State Significant Development Application – SSD 9472

Proposed Sikh Grammar School – 151-161 Tallawong Road, Rouse Hill (Lots 42 & 43 DP 30186)

Table 1: Response Matrix

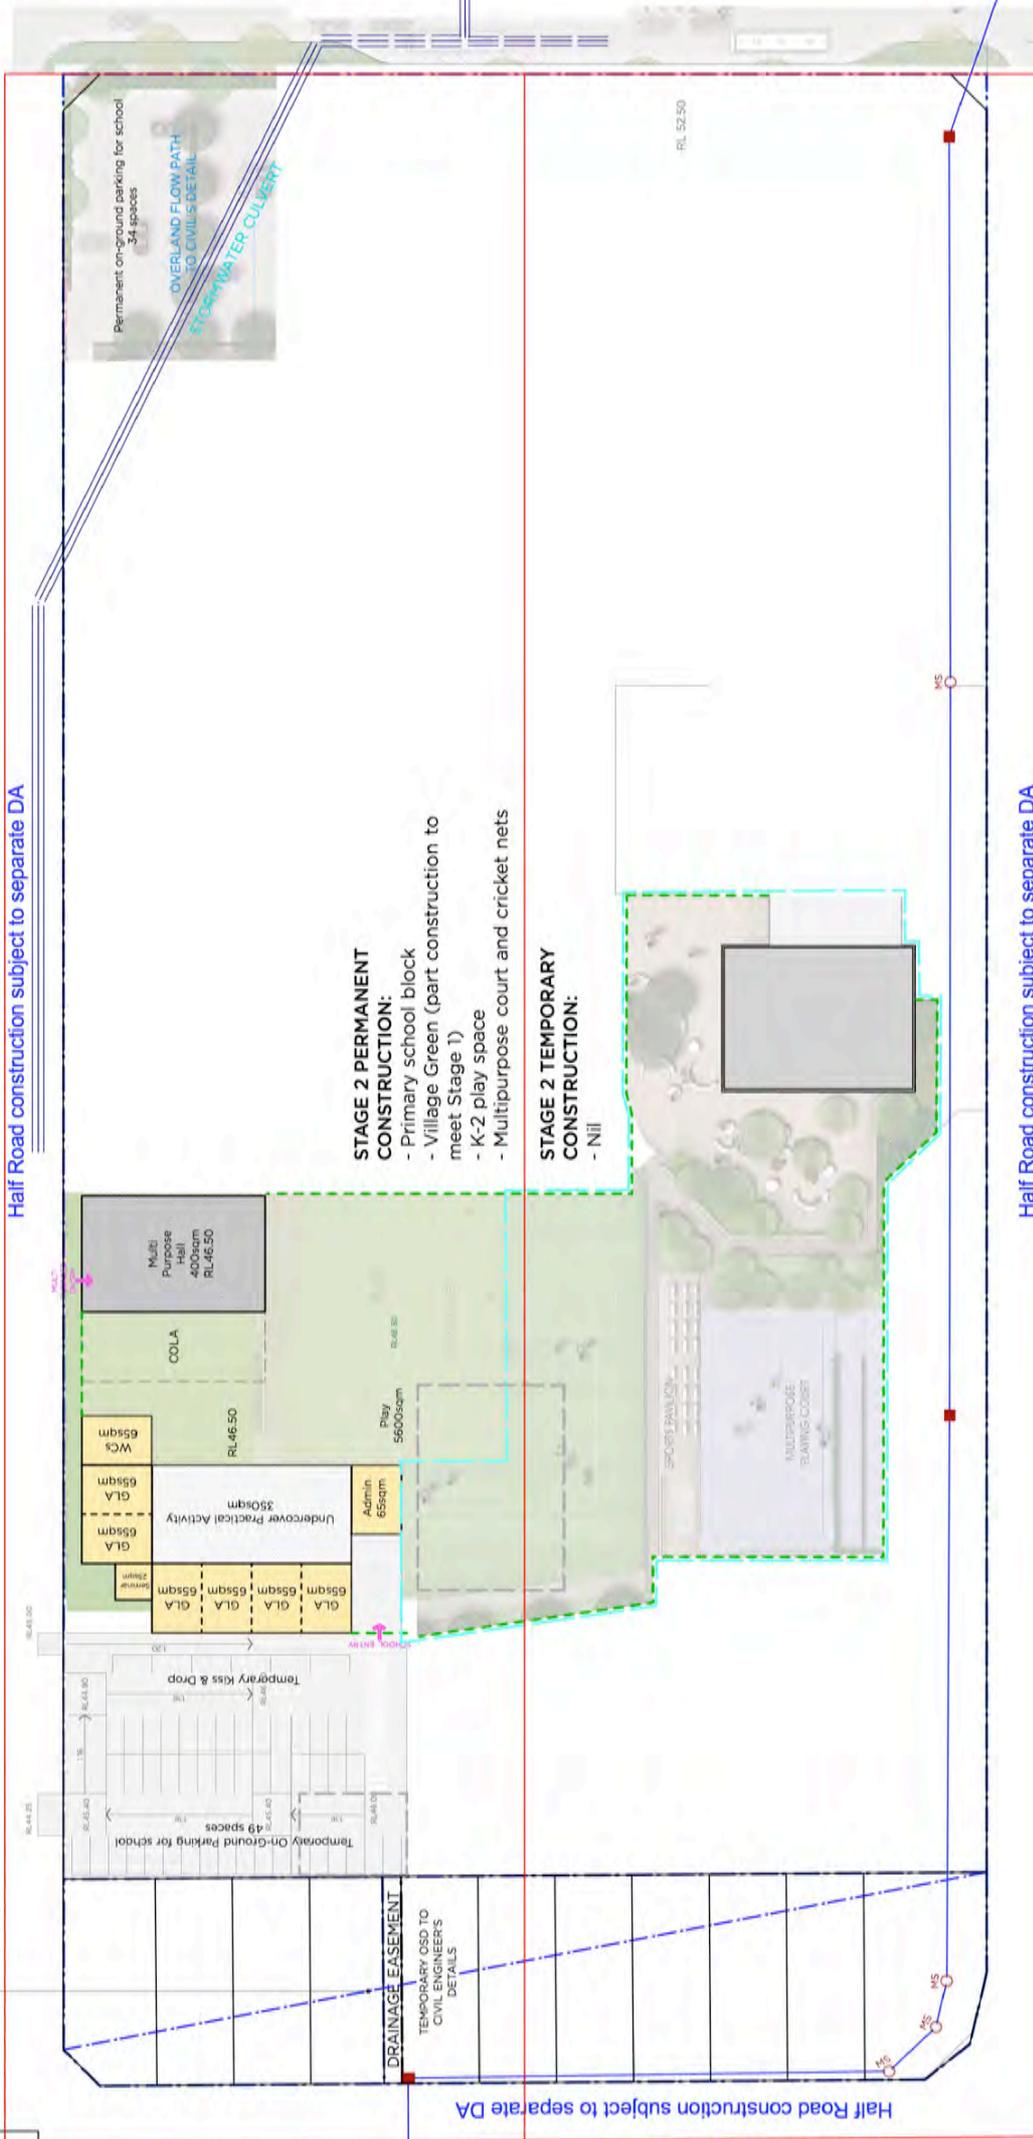
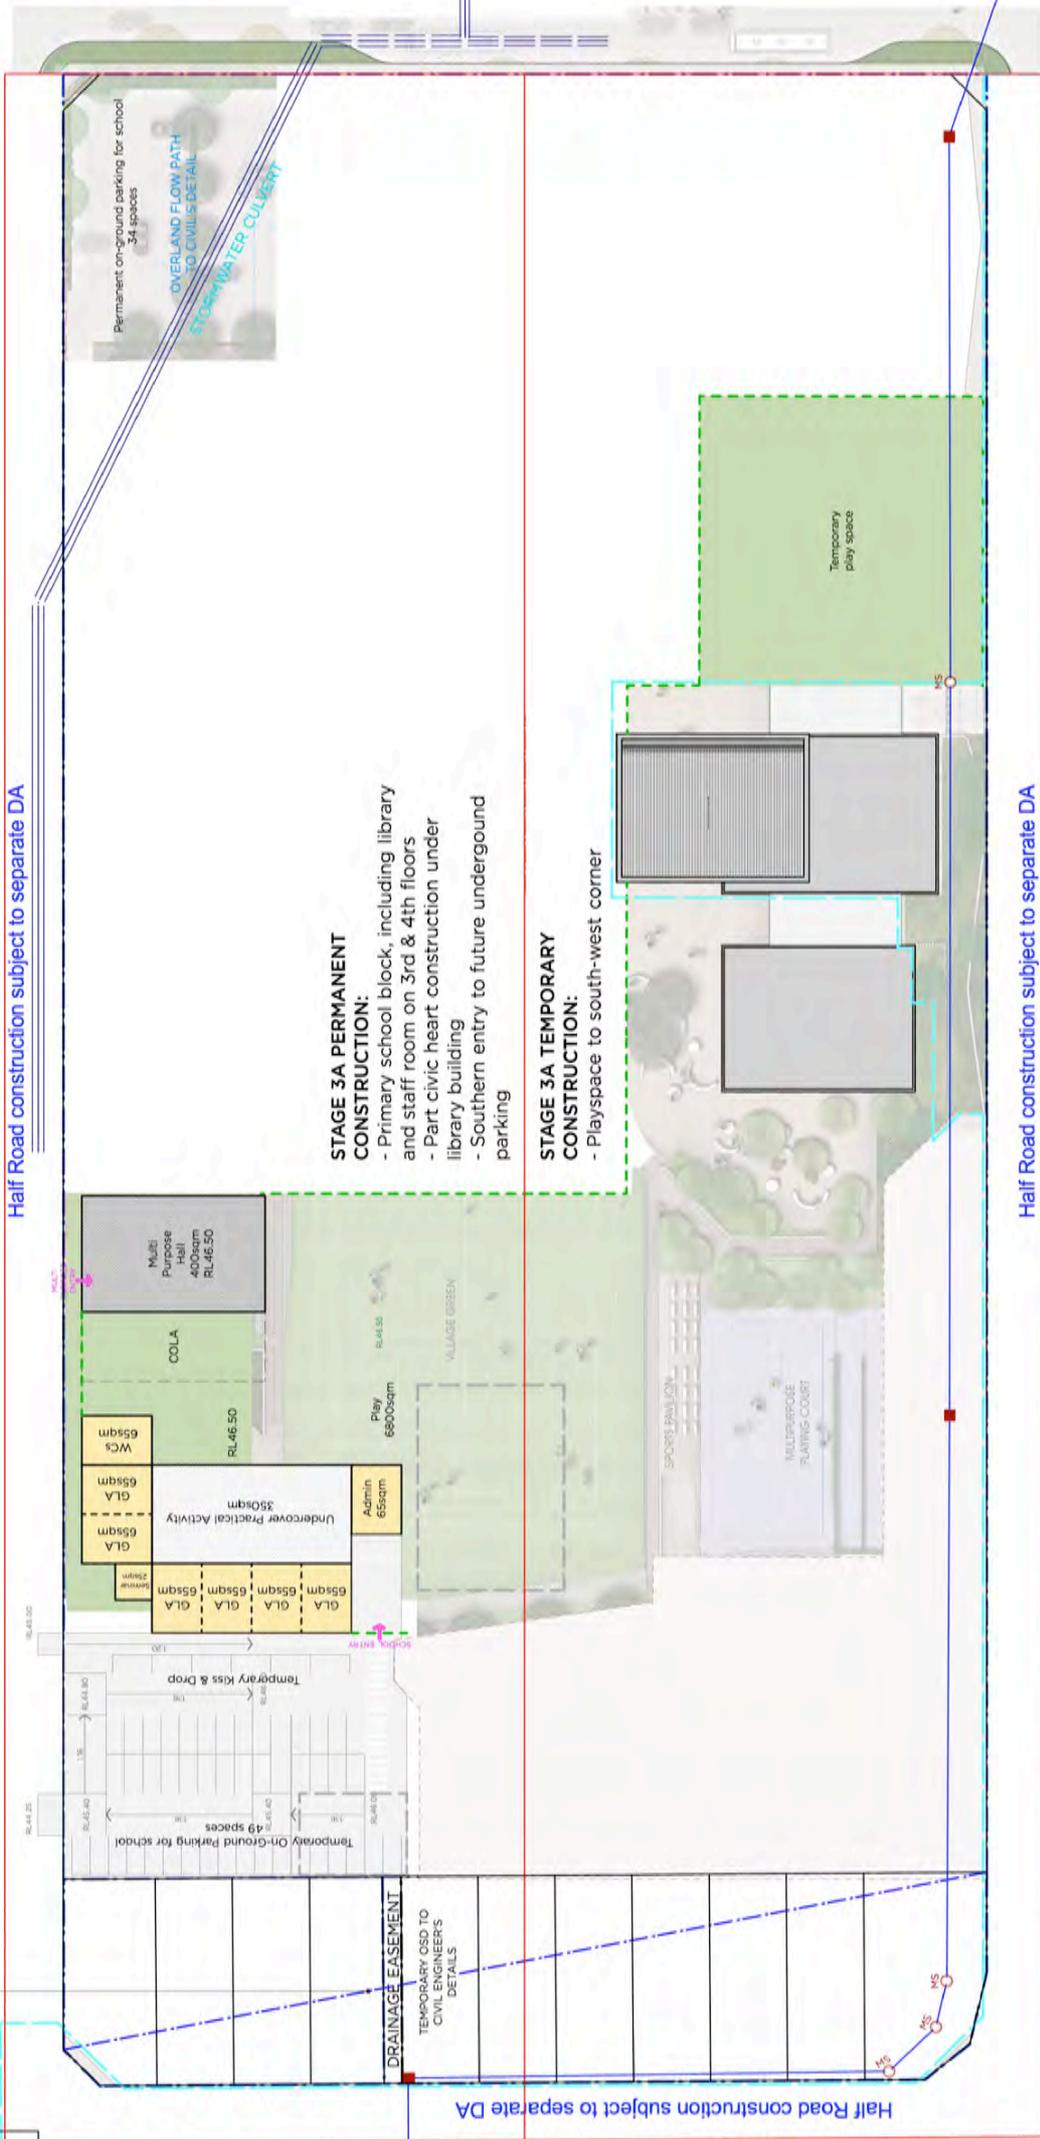
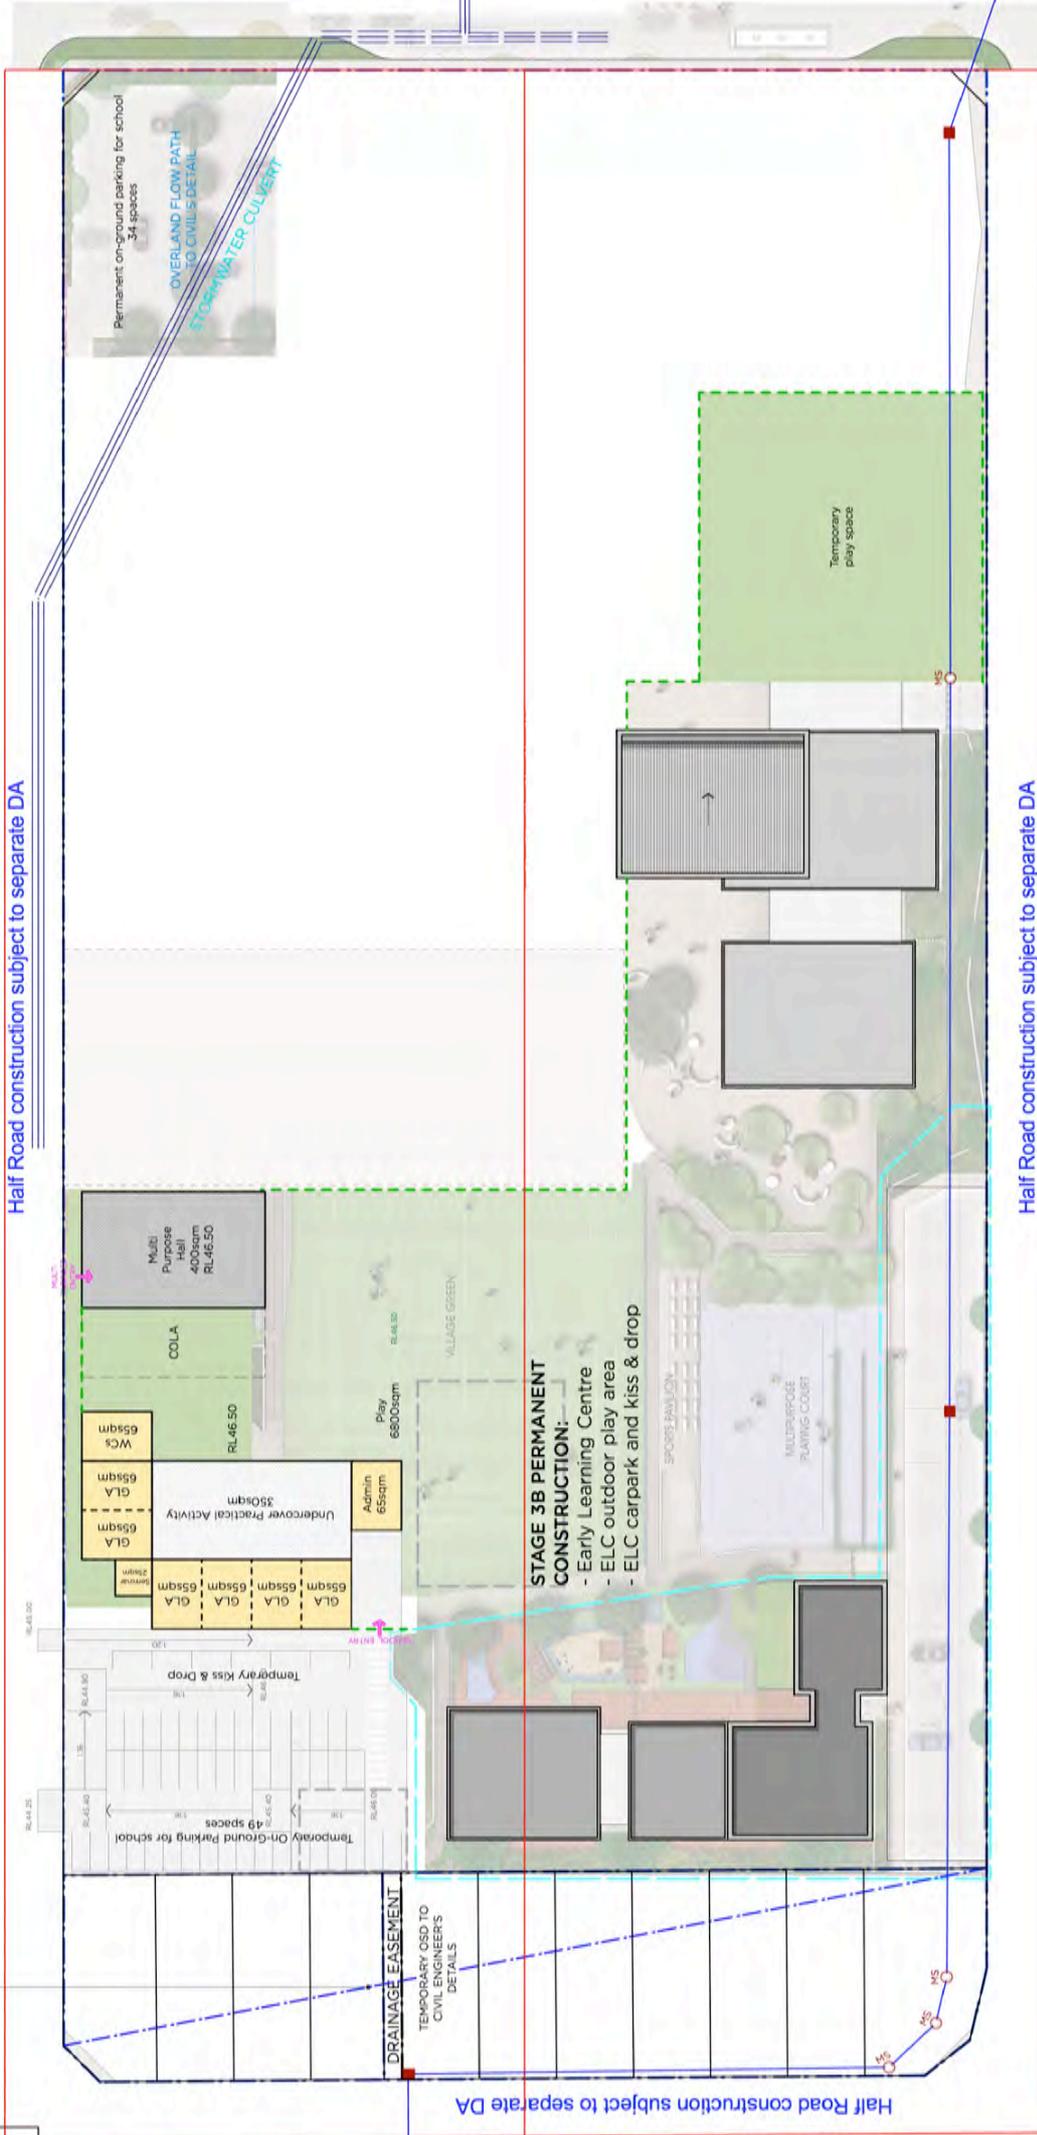
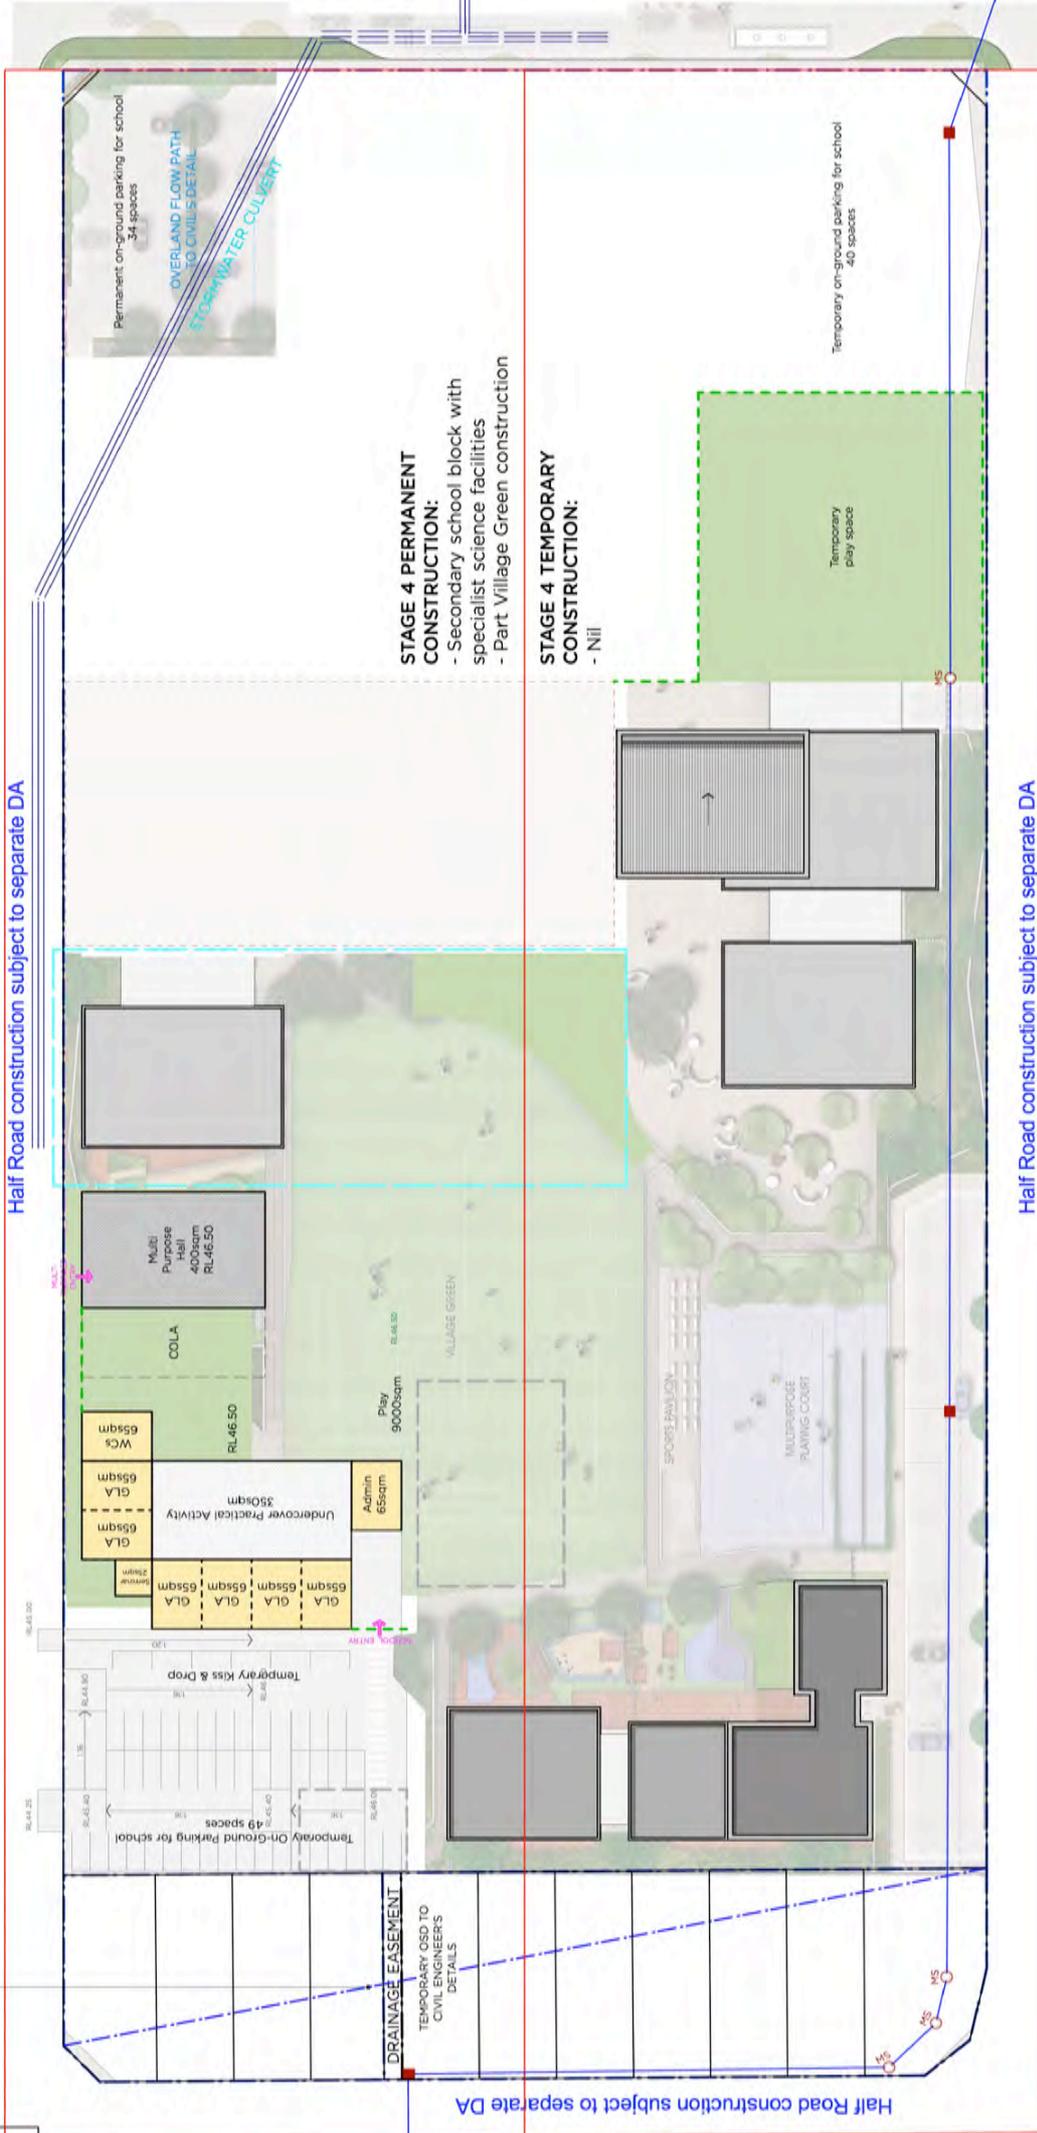
<p><i>The construction staging plan is to be amended to include timeframes of the duration of each of the construction stages (i.e. Jan 2021-Jan 2022).</i></p>	<p>pertaining to each construction stage of the Proposal (refer to Appendix 4). It is noted, that construction stage timeframes may vary depending on relevant Construction Certificates being obtained based on the requirement and demand for each component of the School and associated buildings / particulars.</p>
<p><i>Details are to be provided of the arrangements to be put in place during the staged operation of the site whilst construction is ongoing to ensure the safety of students, staff, other visitors and the public. Details are to include:</i></p> <ul style="list-style-type: none"> ▪ <i>timeframes of staging.</i> ▪ <i>safety arrangements, including how operational areas would be separated from areas of ongoing construction.</i> ▪ <i>access arrangements, including how school access areas would be safety separated from construction access.</i> ▪ <i>how the staging relates to the anticipated provision of local infrastructure, particularly the construction of full road carriageways surrounding the site.</i> 	<p>The Architectural Plans and Operational Plan of Management have been amended to consider and satisfactorily address the adjoining item pertaining to details of arrangements and protocols to be implemented during the staged construction and concurrent operation with respect to the Proposal's varied stages (refer to Appendix 2, 4 & 5).</p>
